Ribble Valley Borough Council  
Housing & Development Control

Application no: **3/2021/0269**

Address: **6 The Arches Whalley BB7 9SG**

Proposal: **Alterations and change of use from art gallery (class F) to ground and first floor flats (class C3).**

drawing
Proposed Alterations

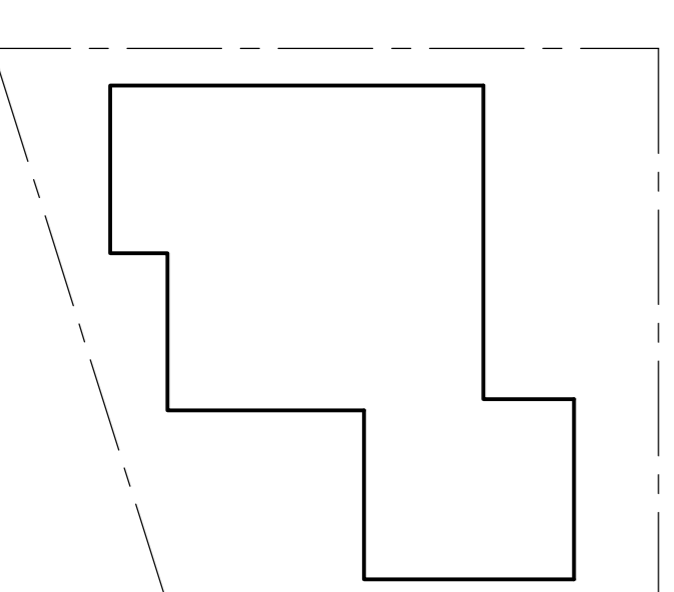
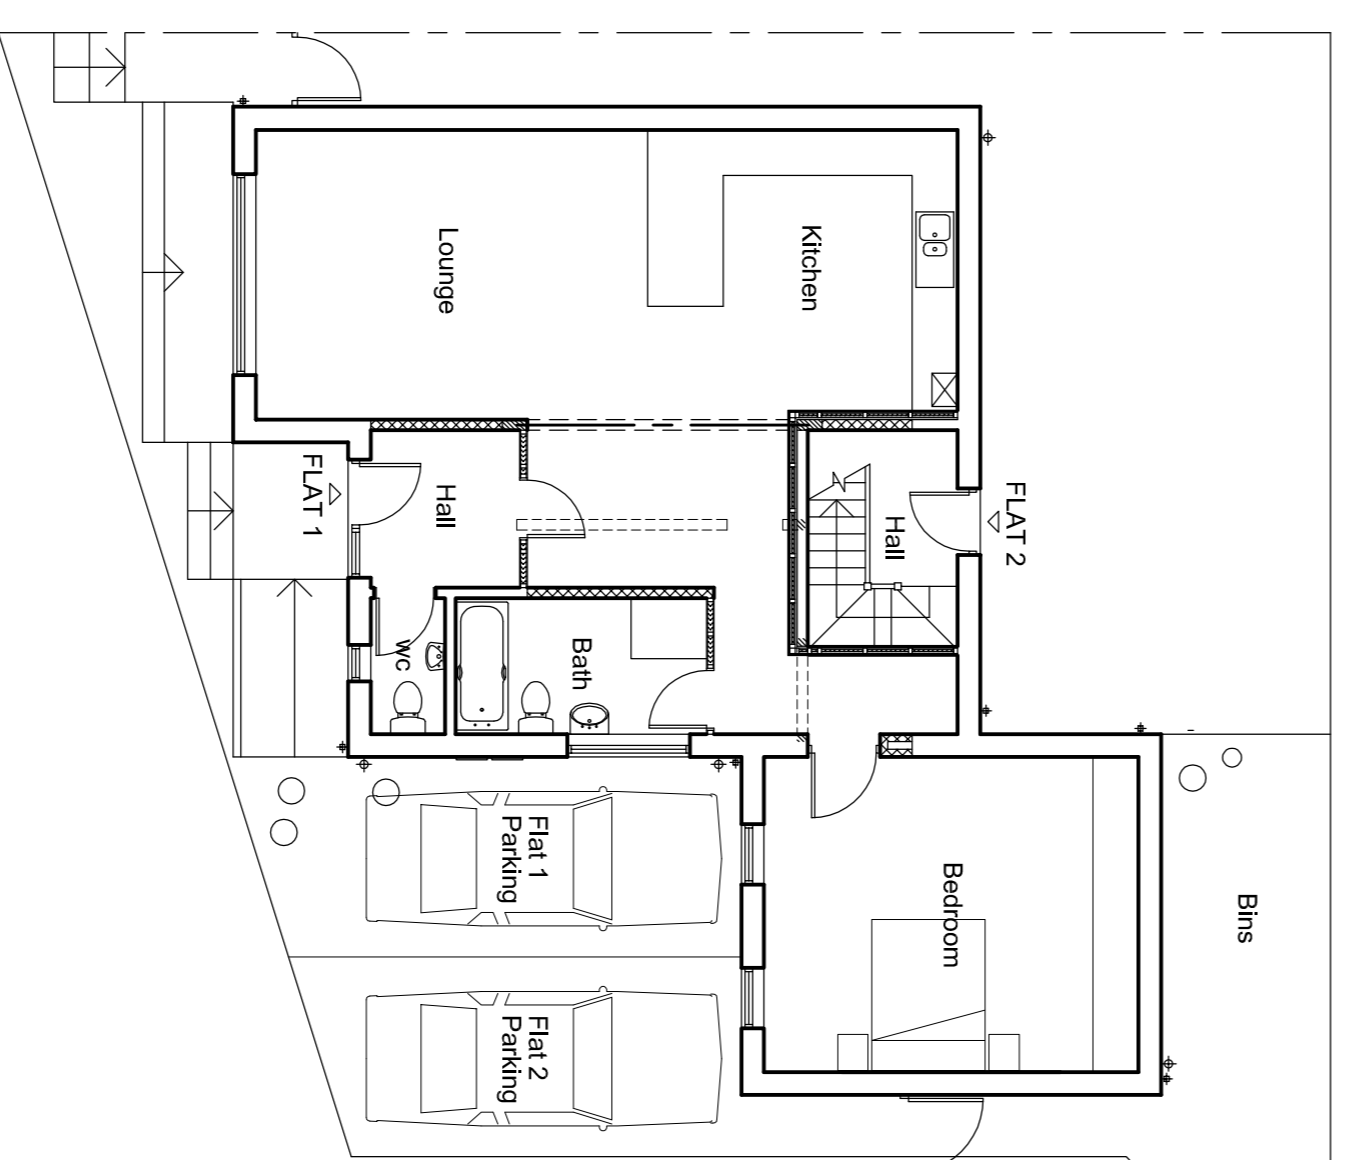
The LHA have reviewed David Haworth drawing number 1421/01 Rev A titled "Proposed Alterations" and are satisfied that the access arrangements complies with the LHAs guidance and so have no further comments to make.

The LHA have reviewed David Haworth drawing number 1421/01 Rev A titled "Proposed Alterations" and understands that the 2x 2 bed flats will have access to one car parking space each.

For the site to comply with the Joint Lancashire Structure Plan, a flat with 2 beds is required to provide 2 car parking spaces. Therefore, there is a shortfall in 2 spaces for the 2 flats.

Notwithstanding this the LHA will accept the shortfall in the parking at the site. This is because the site is in a sustainable location within walking distance to the centre of Whalley where local amenities and bus services are found. Not only this but the site is adjacent to Whalley Train Station which has regular services to Blackburn and Clitheroe. Therefore, with these factors in mind, the LHA have no objection to the proposal.

1. The development hereby permitted shall not be occupied until such time as the parking and turning facilities have been implemented in accordance with David Haworth drawing number 1421/01 Rev A. Thereafter the onsite parking provision shall be so maintained in perpetuity.
